Development Review Checklist

IS-FBC

Level I / Level II / Level III / Master Plan
 Project Name: Home 2 Hotel
 Address: 203 Fore Street
 Description: Alteration / Addition / **New Construction**
 Date Received: 11/22/17 Prelim / Final
 Planner: Caitlin Cameron

LANDSCAPE PLAN
 1/16" = 1'-0"

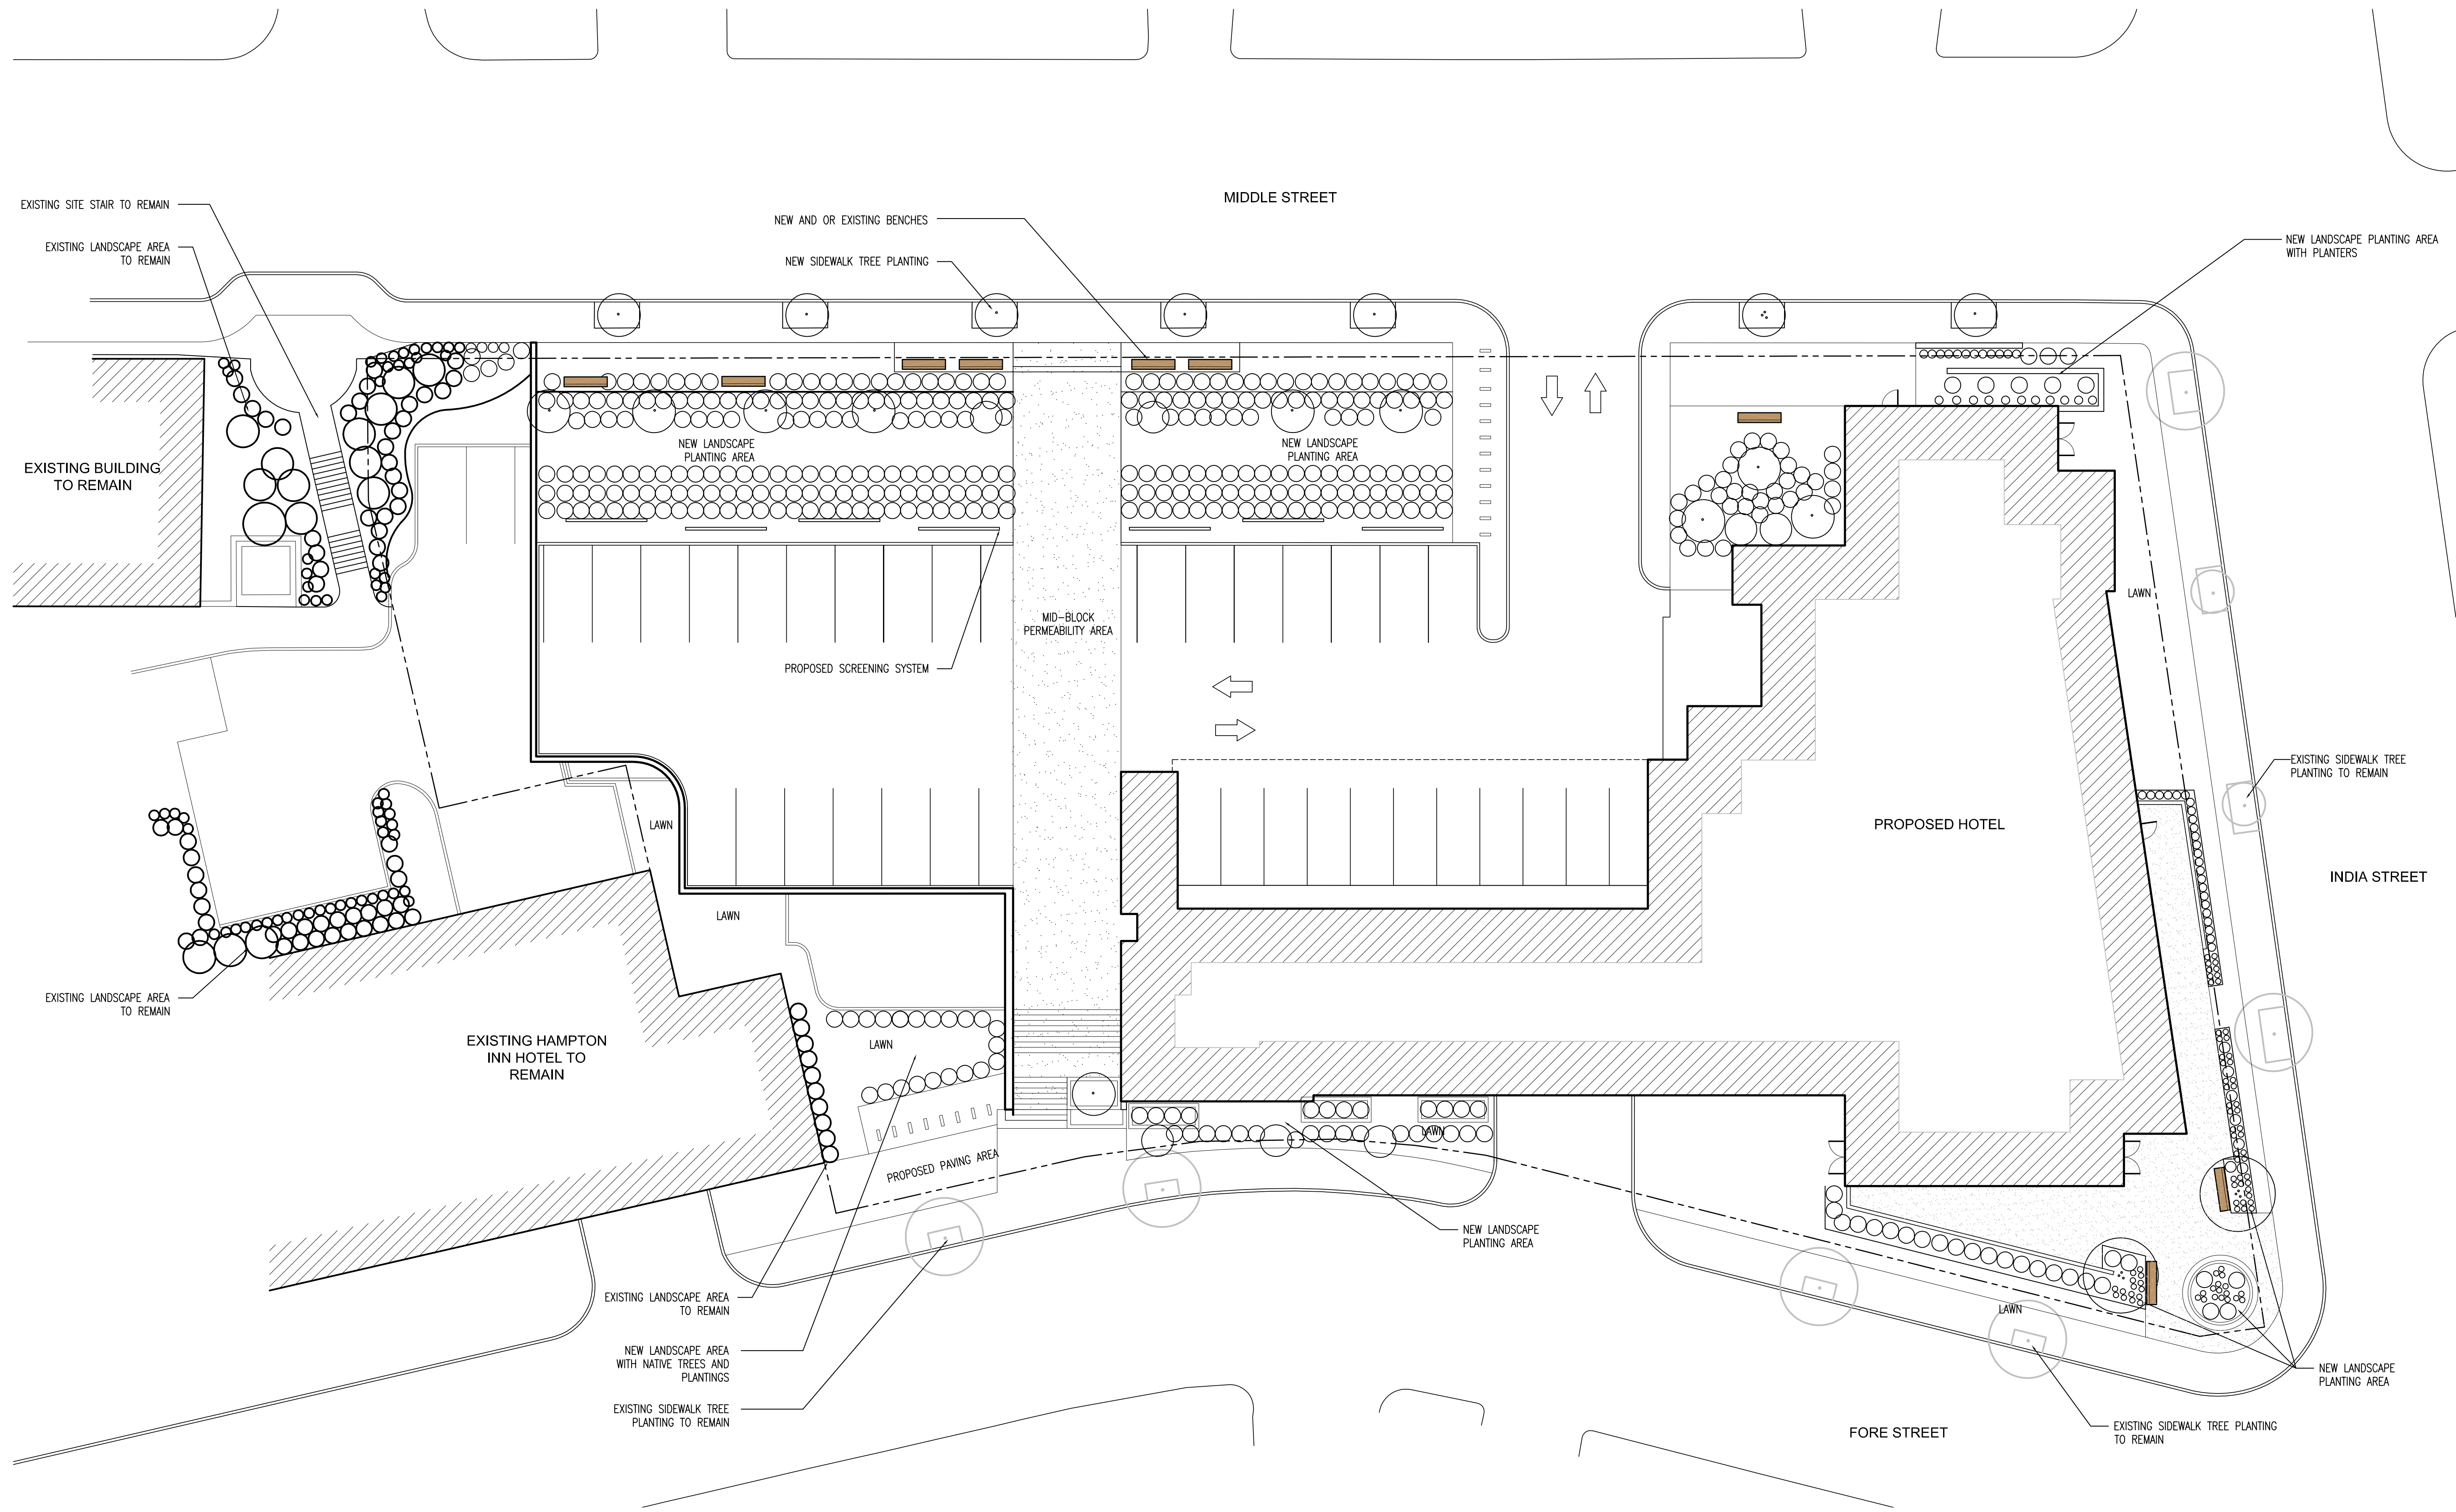
Attached Buildings	<input type="checkbox"/>	<input type="checkbox"/>	<input type="checkbox"/>	<input checked="" type="checkbox"/>	
Landscaping & Screening					
Surface Parking	<input type="checkbox"/>	<input checked="" type="checkbox"/>	<input checked="" type="checkbox"/>	<input type="checkbox"/>	Surface parking must be screened from view of Middle Street and Fore Street sidewalk
1 st Lot Layer - Height	<input type="checkbox"/>	<input type="checkbox"/>	<input type="checkbox"/>	<input checked="" type="checkbox"/>	
1 st Lot Layer – Perm.	<input type="checkbox"/>	<input type="checkbox"/>	<input type="checkbox"/>	<input checked="" type="checkbox"/>	
Other Lot Layer - Height	<input type="checkbox"/>	<input type="checkbox"/>	<input type="checkbox"/>	<input checked="" type="checkbox"/>	
Building Addition - Length	<input type="checkbox"/>	<input type="checkbox"/>	<input type="checkbox"/>	<input checked="" type="checkbox"/>

Drawing file: Prelim / P2_Project Summary Sheet.pdf

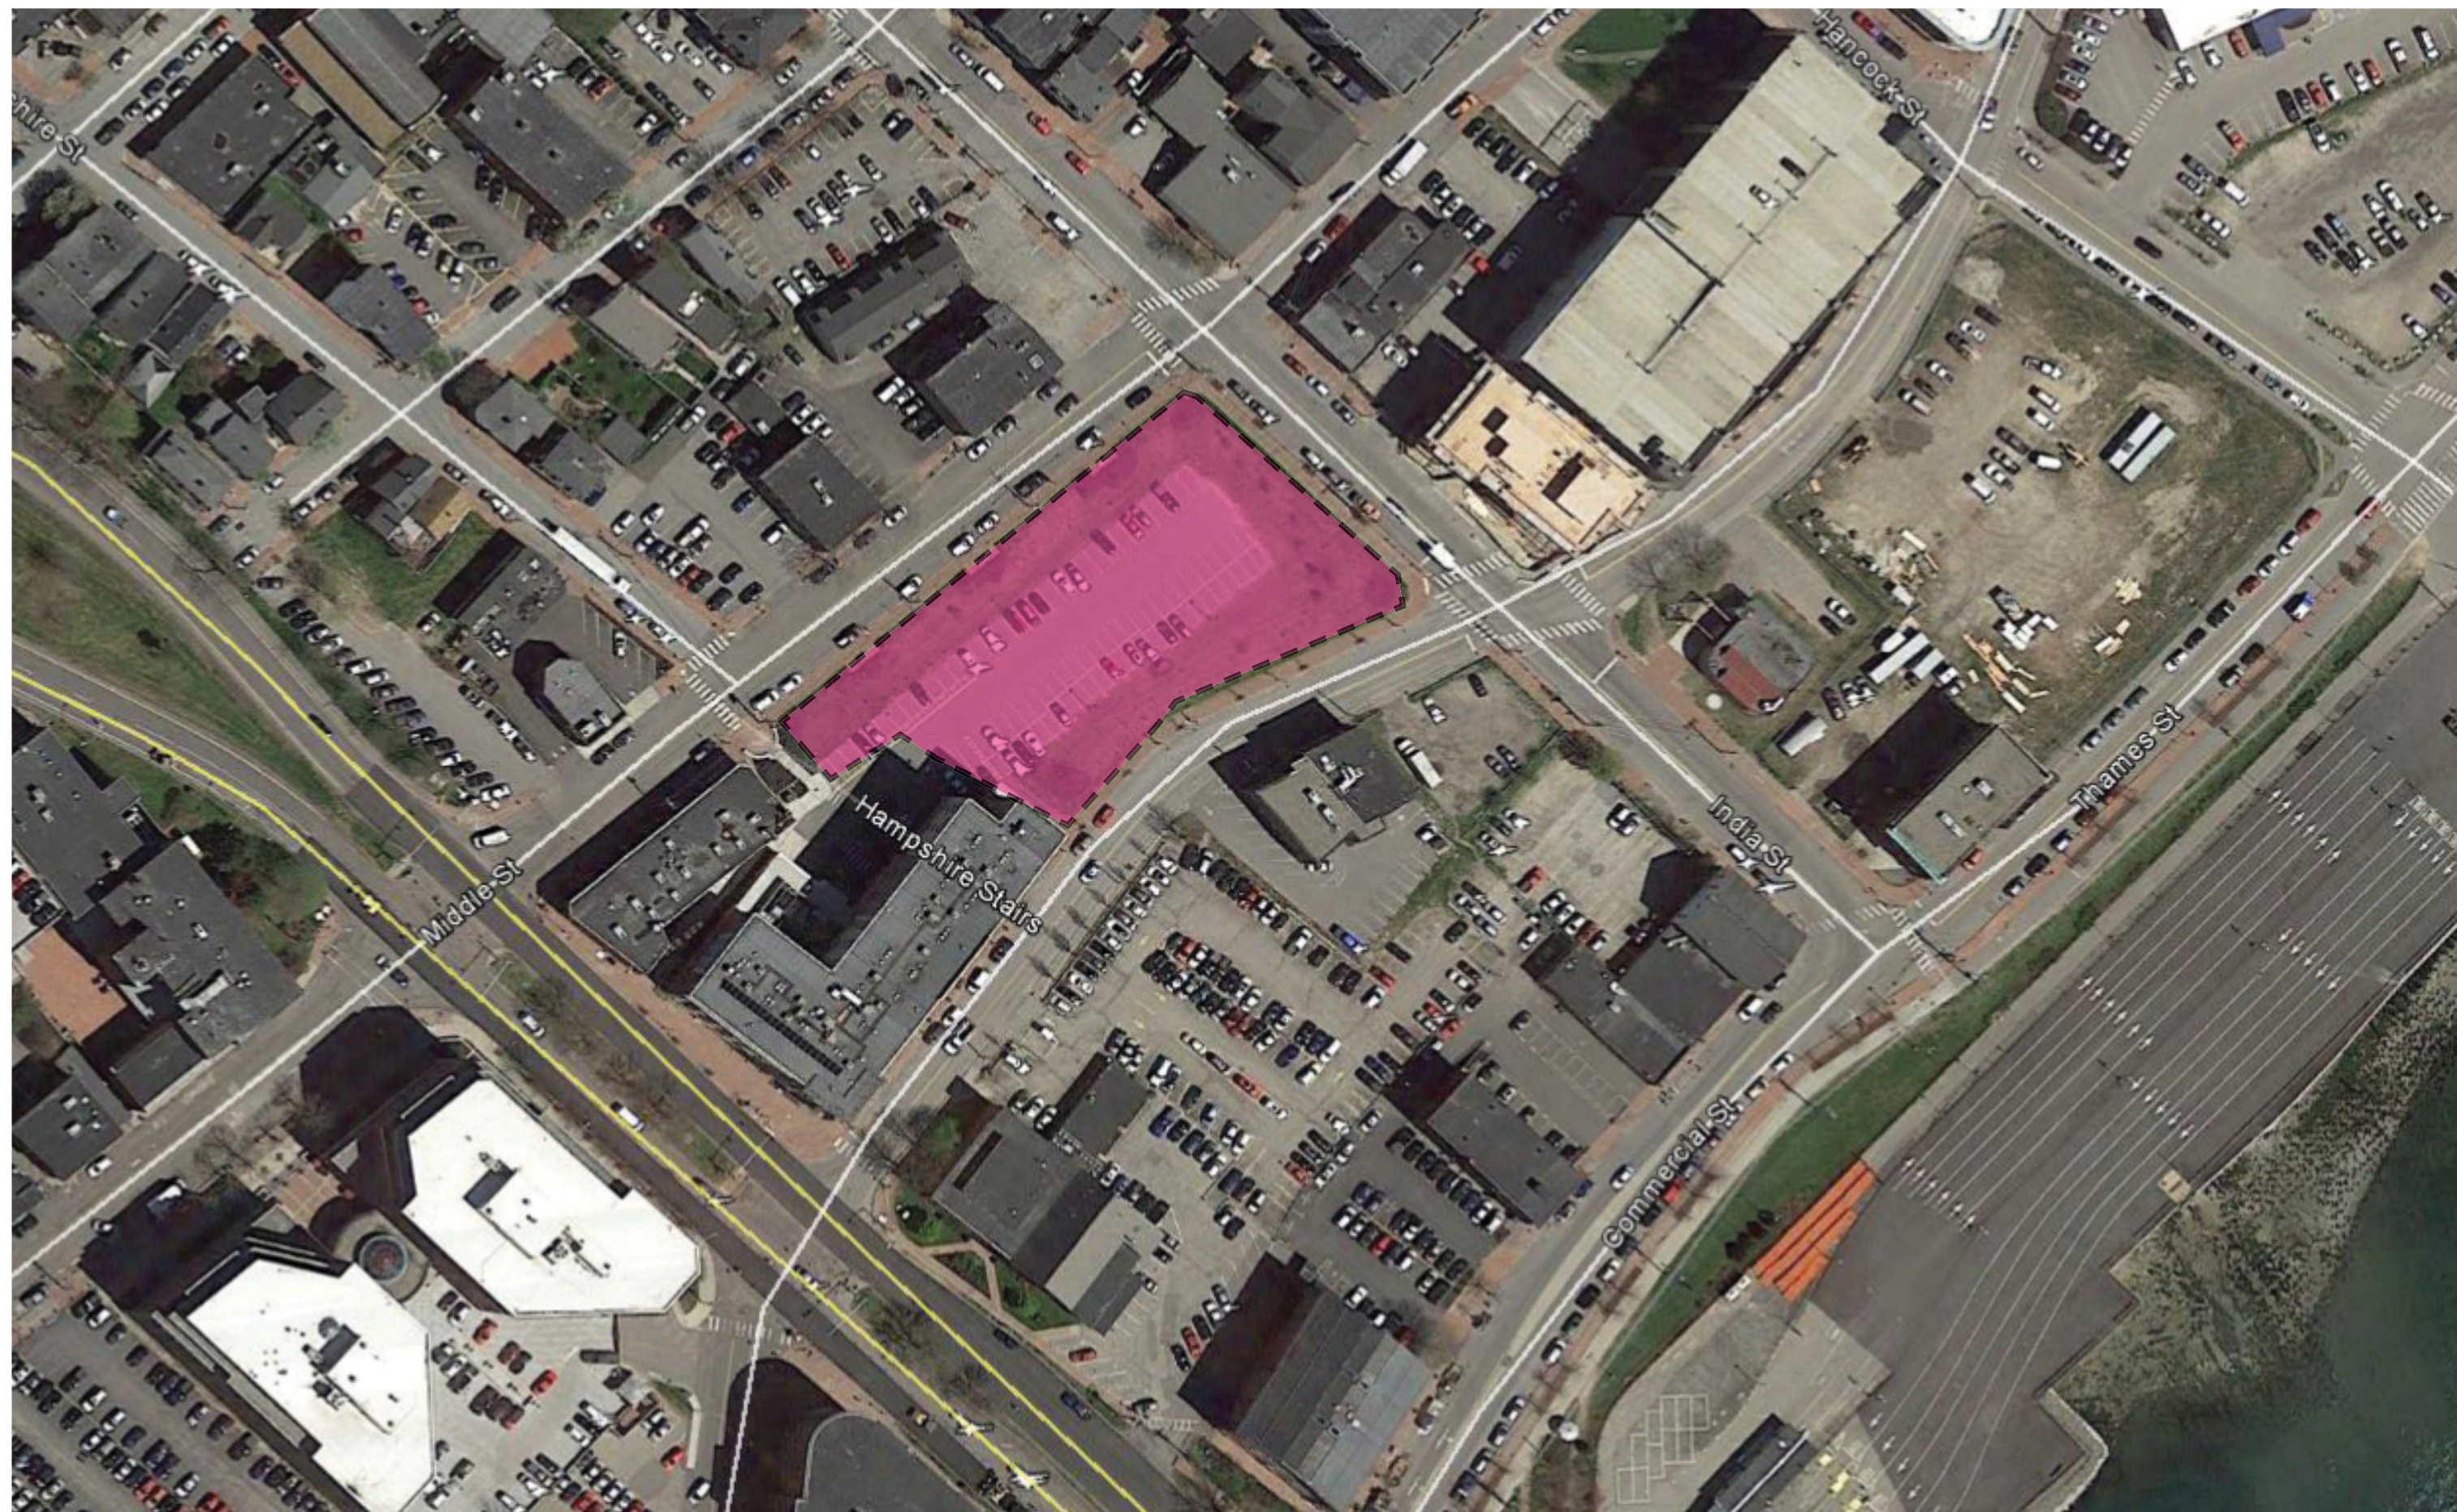
(d) Parking Standards	<input type="checkbox"/>	<input checked="" type="checkbox"/>	<input checked="" type="checkbox"/>	<input type="checkbox"/>	50 + 93 = 143 spaces required, 120 spaces provided
Existing Parking - Addition	<input type="checkbox"/>	<input type="checkbox"/>	<input type="checkbox"/>	<input checked="" type="checkbox"/>	
SUBDISTRICT DIMS REQ.					
Siting Standards					
Orientation	<input type="checkbox"/>	<input type="checkbox"/>	<input checked="" type="checkbox"/>	<input type="checkbox"/>	UA orientation required (Waiver requested)
Corner Condition	<input checked="" type="checkbox"/>	<input type="checkbox"/>	<input type="checkbox"/>	<input type="checkbox"/>	UT/UA intersection; height stepbacks provided
Lot Coverage	<input type="checkbox"/>	<input checked="" type="checkbox"/>	<input type="checkbox"/>	<input type="checkbox"/>	Need an updated survey with lot area
Frontage Requirements

Garage Door Setback	<input type="checkbox"/>	<input checked="" type="checkbox"/>	<input type="checkbox"/>	<input type="checkbox"/>	Garage opening is at least 10’ from street – not clear if door is proposed
Garage Door Opening	<input type="checkbox"/>	<input checked="" type="checkbox"/>	<input type="checkbox"/>	<input type="checkbox"/>	Garage opening is 33’ (20’ max door width) – not clear if door is proposed
